**WELWYN HATFIELD BOROUGH COUNCIL
EXECUTIVE DIRECTOR - PLANNING, PUBLIC PROTECTION AND GOVERNANCE**

DELEGATED APPLICATION

Application No: 6/2020/2821/HOUSE
Location: 1 Northaw Place Coopers Lane Northaw Potters Bar EN6 4NQ
Proposal: Construction of a domestic tennis court with surround fencing
Officer: Ms Kirsty Shirley

Recommendation: Refused

Proposed Tennis Court at 1 Northaw Place - Block Plan

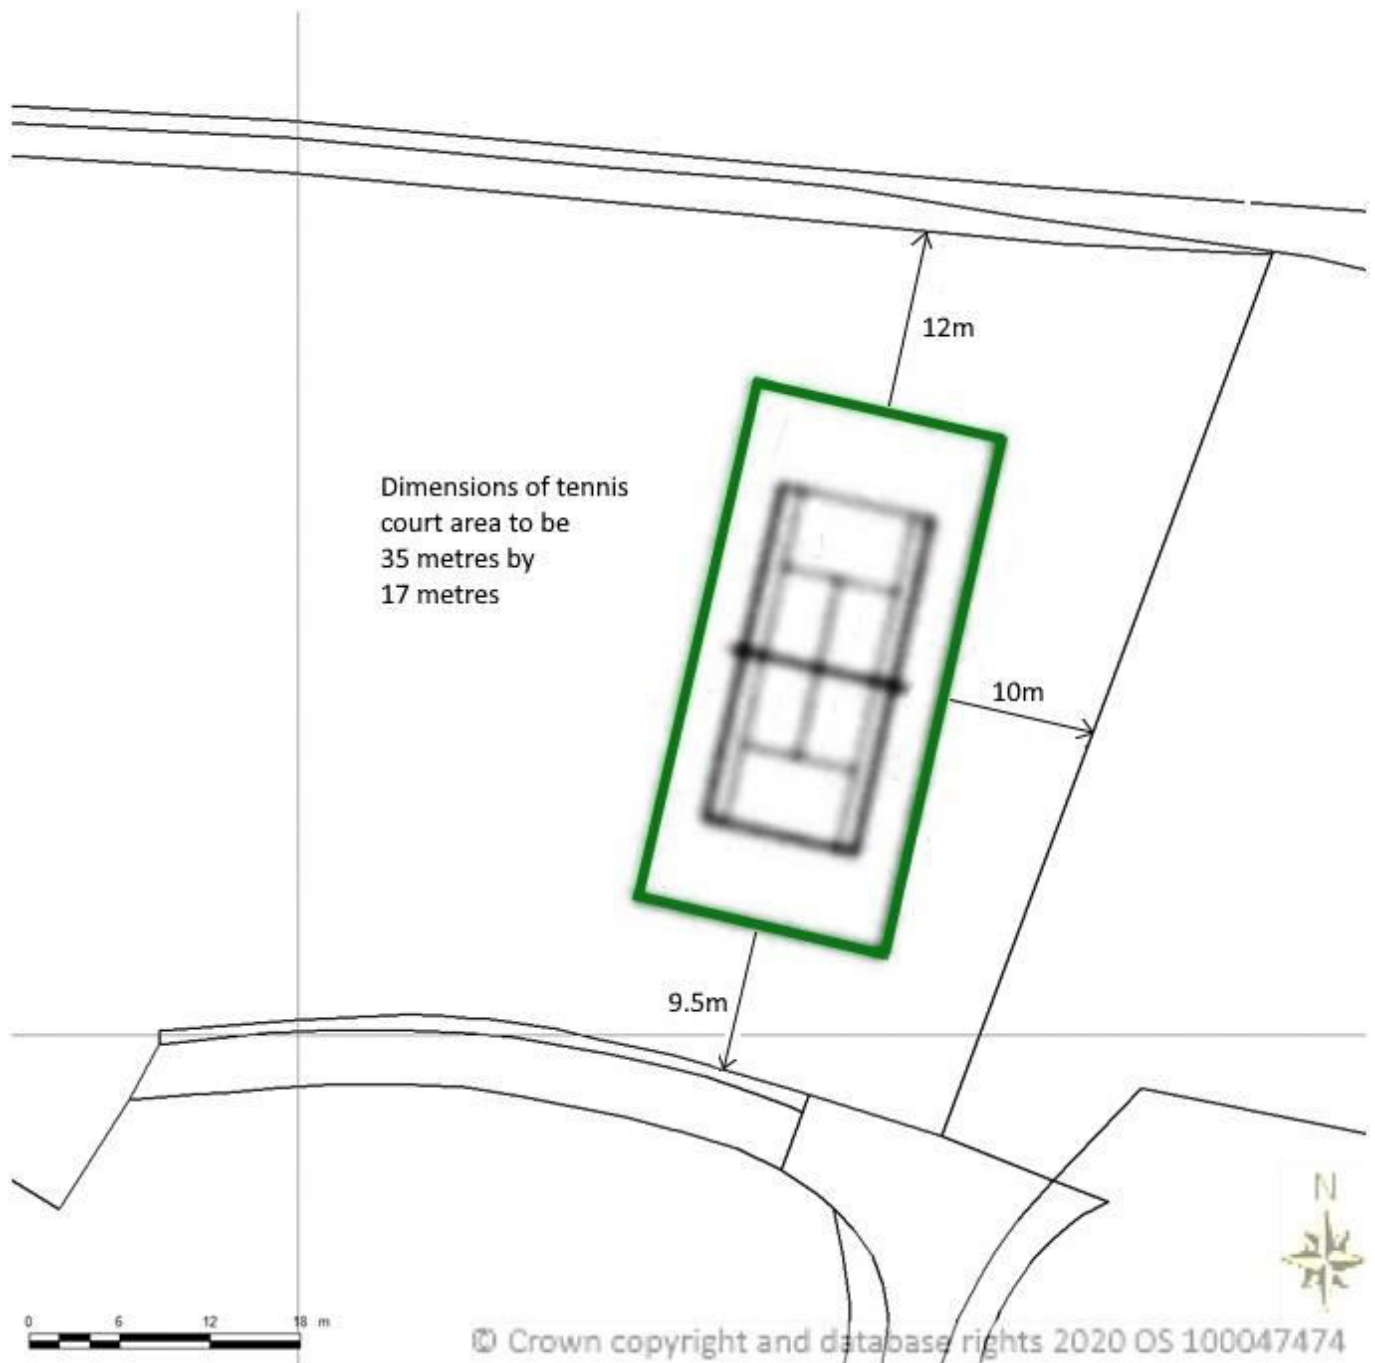
The application concerns a Grade II* Listed mansion of outstanding historical interest and national importance, with landscape of Northaw Place remaining historically open. The proposed tennis court is located to the north east of the house on land which has always been within the wider gardens of the house and has historically remained open and free of development.

Floor Plan – Proposed Tennis Court at 1 Northaw Place

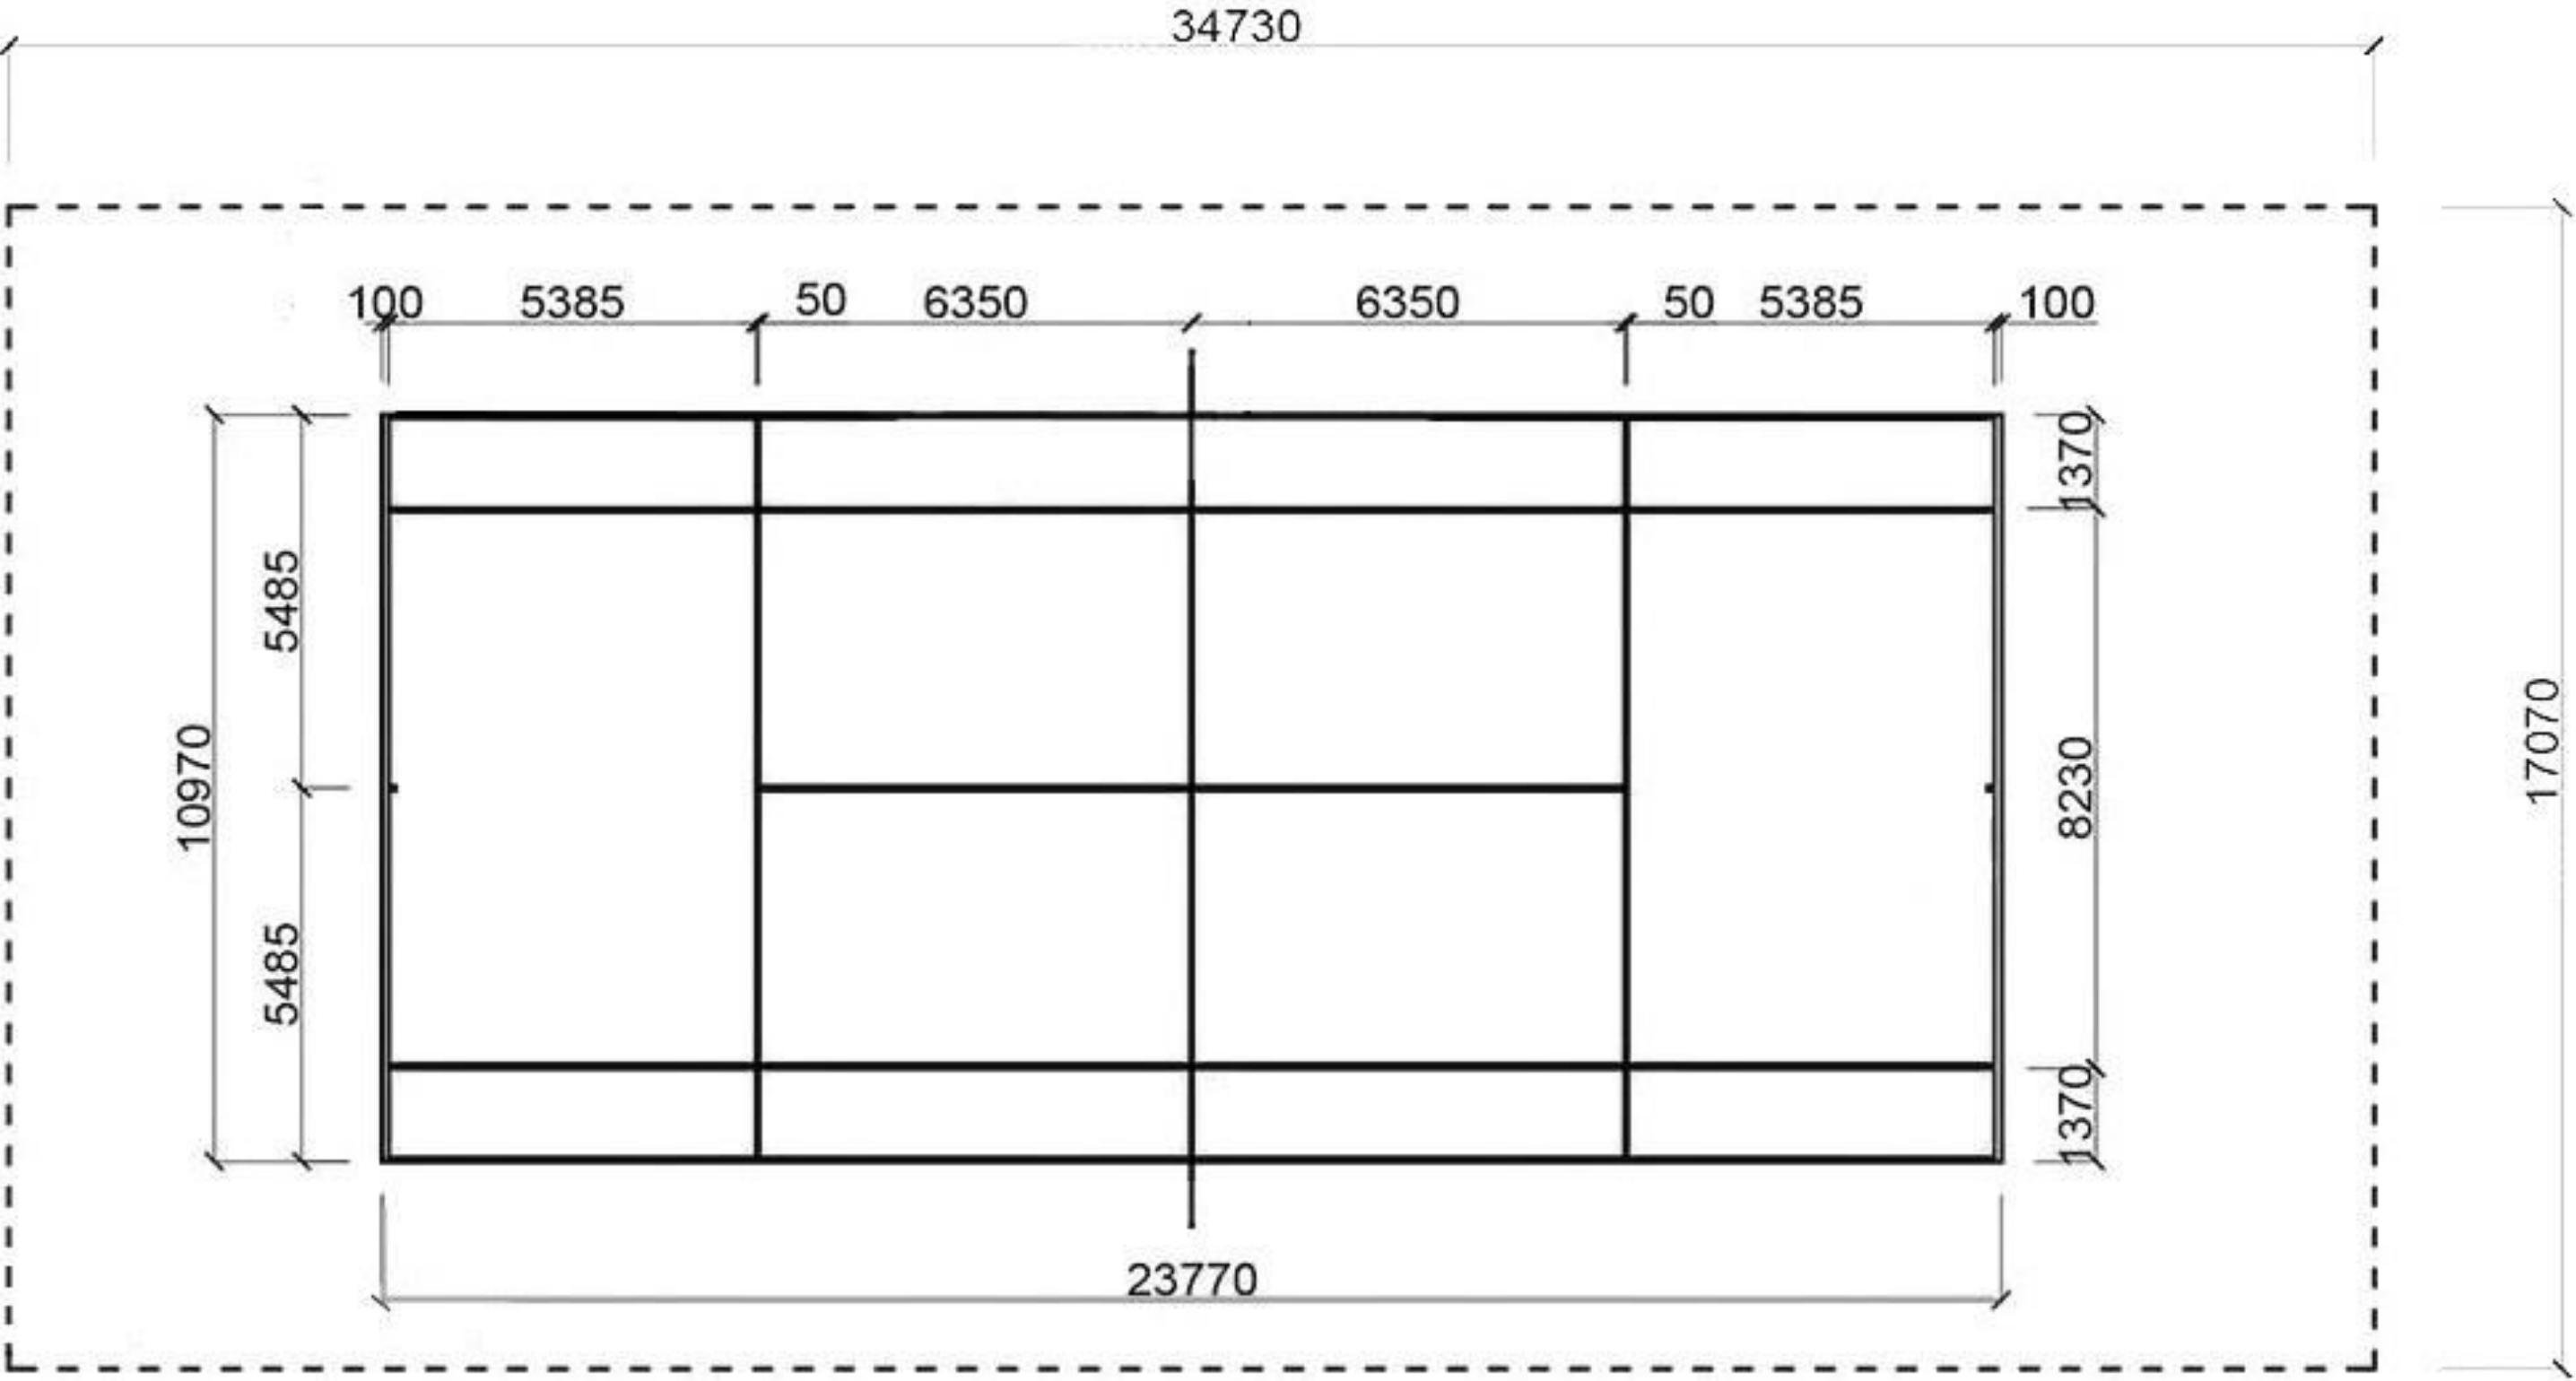
The proposed tennis court and fence will introduce a large, modern feature into the garden which would detract from the setting of the listed building. While the features of the tennis court have been designed in consideration of the surroundings and seek to cause minimal interruption to the area, the tennis court and fencing will still be visible as a modern feature and will undermine the appreciation of the listed building in its garden setting

<p>Green Belt</p>	<p>The site is located within the Metropolitan Green Belt as defined by District Plan Policy GBSP1.</p> <p>The proposal seeks to erect a fence to surround the tennis court, which is approximately 2.75m in height and would enclose approximately 595m² of land. The term ‘building’ is not defined in the NPPF but the definition in the Town and Country Planning Act 1990 refers to ‘any structure or erection’. As a result, it is considered that the proposed fencing should be treated as a ‘building’ for the purposes of the NPPF.</p> <p><i>Appropriateness</i></p> <p>Paragraph 143 of the NPPF advises that inappropriate development is, by definition, harmful to the Green Belt and should not be approved except in very special circumstances. Paragraph 145 of the NPPF explains that construction of new buildings should be regarded as inappropriate in the Green Belt, except for listed exceptions. One relevant exception is the provision of appropriate facilities for outdoor sport and outdoor recreation, provided the facilities</p>

While the fencing has been designed to be in keeping with the landscaped area, the height and scale of the fencing would create an incongruous protrusion within the lawn landscaped garden. Additionally, the creation of a significant amount of hardstanding to facilitate the tennis court would result in the alteration of a significant portion of land which would impact on both the physical and visual openness of the Green Belt. The development would therefore have a harmful impact on the openness of the Green Belt, contrary to the NPPF.
